WESTECH COMPANY

September 28, 2018

In accordance with your comments, ESAs comments and Public Comments on the permit application for a single family residence at 8114 West Mercer Way, Westech Company revised our Mitigation Plan and Monitoring Plan Report (dated September 2018) which has been submitted to you by Mr. Benny Kim. As you have also requested, this letter discusses the various comments on a point-by-point basis. I hope that this is helpful information.

Land Use Review Comments

Figure 4. Site Plan Showing Proposed Buffer Reduction and Addition Areas

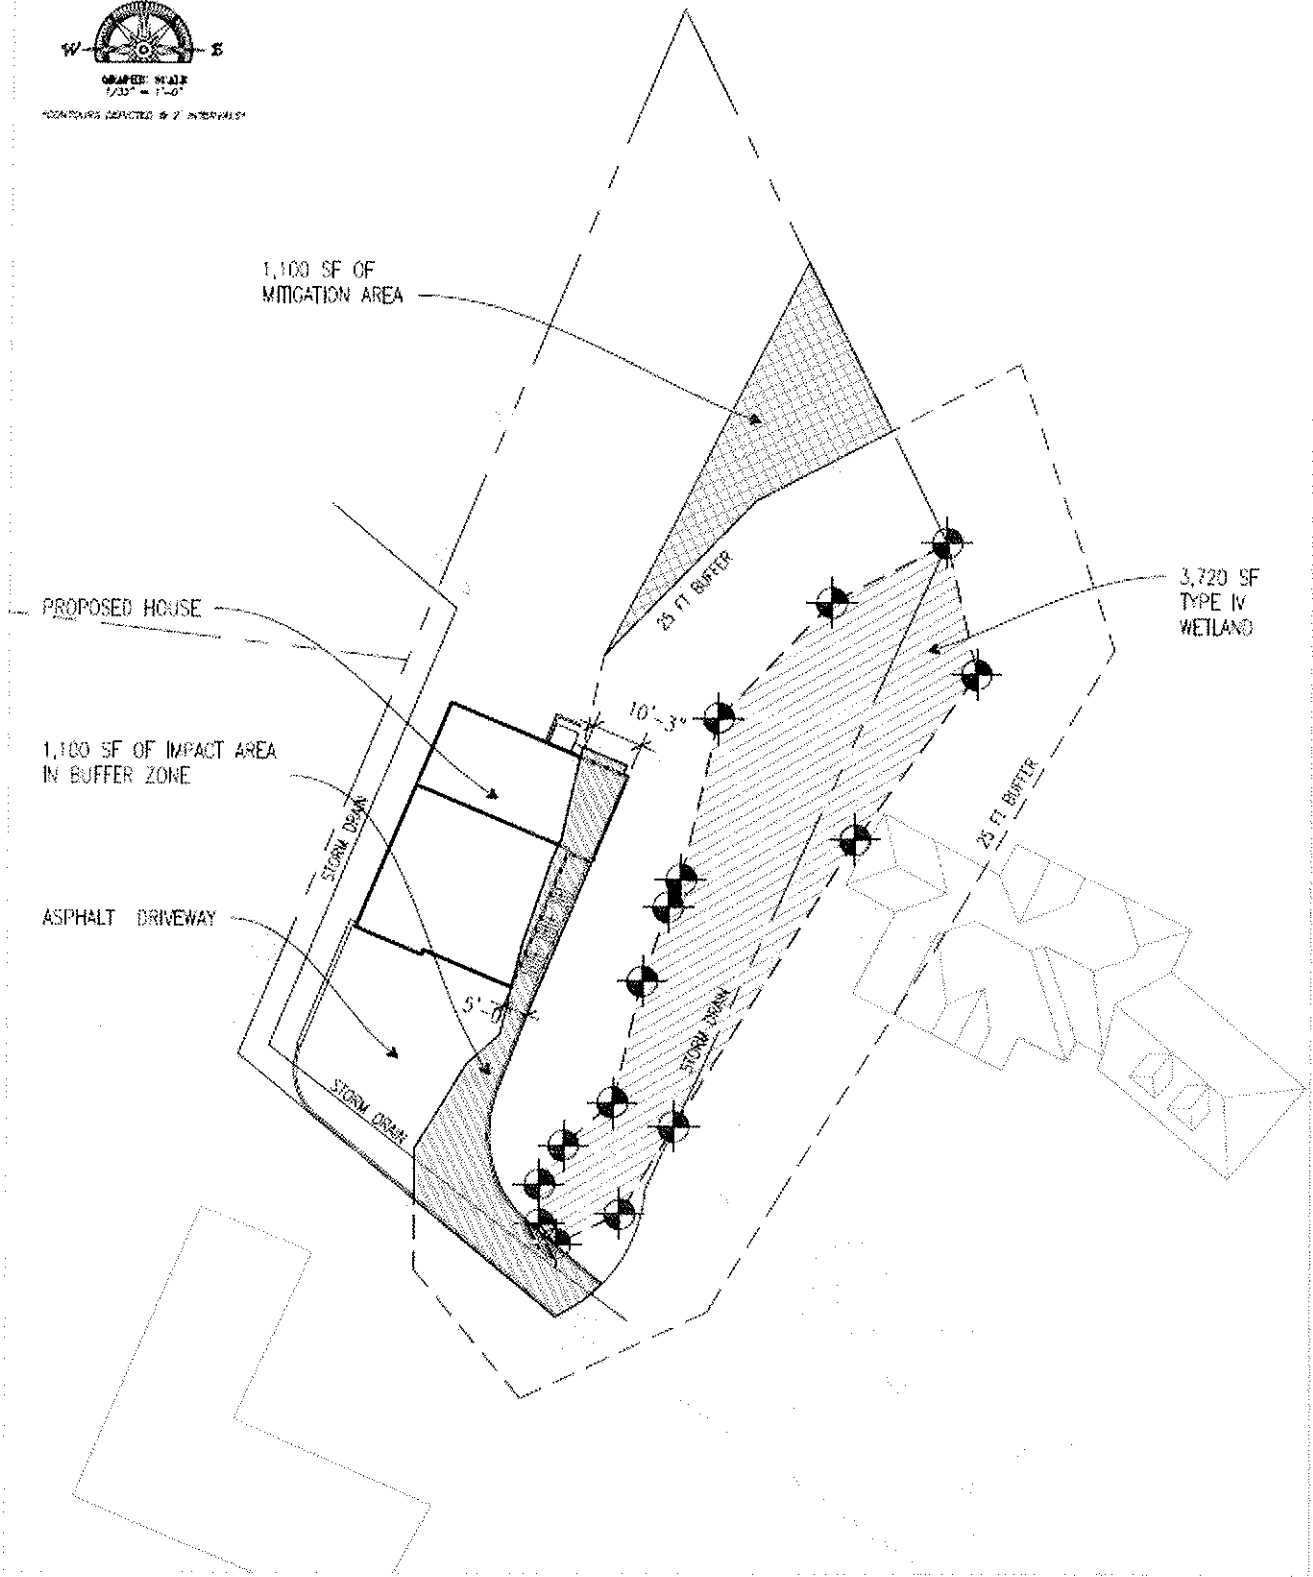
1. Options to Proceed

2. ESA Review

4. Site Plan

In response to this comment, the applicant (Mr. Benny Kim) has chosen item (b), and redesigned the residence to lie outside of the minimum 25 foot buffer (see Site Plan in Figure 4, of the Mitigation & Monitoring Plan hereafter M&M Plan). The new design and mitigation will result in a net improvement of wetland function with the new Enhancement Area as shown in that Figure (4). This will comply with MICC 19.07.070(3).

a) The plan (Figure 4 in the M&M Plan) shows the 200 square foot wet area, which was checked and found not to satisfy the requirements of a wetland. A data sheet was appended to the report to demonstrate that finding (Appendix A).

b) The driveway was narrowed and reconfigured as requested by ESA and a row of trees is required along the north edge of the driveway as requested (see Figure 4 in the M&M Plan)

- a) The new Site Plan has been revised to show the 25 foot(minimum) and 35 foot (standard) buffers adjacent to the house site.
- b) The 200 square foot “wet area” was studied further and found NOT to constitute a wetland (see Figure 4, Chapter 5.0 and Appendix A of the M&M Plan).
- c). The off-site buffer has been removed from the Plan.
- d) The reduced buffer has been shown for the house and the driveway as requested.
- e) This information regarding steep slopes has been added to the Site Plan.
- f) This information regarding easements will be submitted under separate cover.
- g) This information regarding the property line and dimensions has been added to the Site Plan.
